**SUBMISSION TO THE DEPARTMENT OF PLANNING AND INFRASTRUCTURE ON THE PROPOSED
NORTH WEST RAIL LINK (NWRL)**

Name: K Jones

Application Number: SSI-5100

Figure 6.11 Cheltenham Services Facility light vehicle access and egress

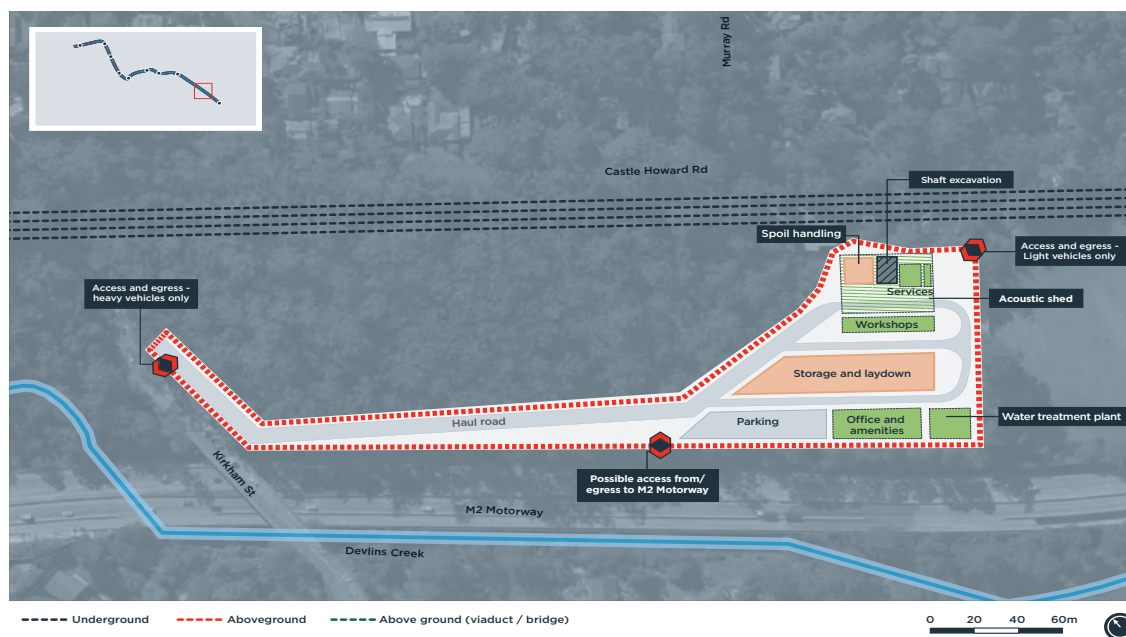
1. The option to construct a new two lane paved road through the Castle Howard Conservation Reserve to Kirkham Street (or Castle Howard Road) near the bridge over the M2 to allow trucks to remove spoil during construction and light vehicle access during operation of the facility will permanently destroy valuable Blackbutt Gully forest.

5. Should the roadway be built, the local streets (Kirkham Street, Castle Howard Road, Murray Farm Road and the bridge over the M2) are narrow, winding and congested and would not be suitable for trucks and, in the event of an emergency, large numbers of emergency vehicles.

6. There are no traffic lights at the corner of Kirkham Street and Beecroft Road. This is a dangerous intersection for traffic and pedestrians and would not be suitable for trucks and emergency vehicles.

I therefore ask that you adopt the alternative option of access to the site for construction and emergency vehicles be via new on and off ramps from the M2 motorway. The current widening and reinstatement of the breakdown lane should allow this access. It is the only practical way to move trucks in and out of the site. In the event of an emergency, many emergency vehicles would need quick access to the site from areas outside Beecroft and Cheltenham as it only has one fire engine.
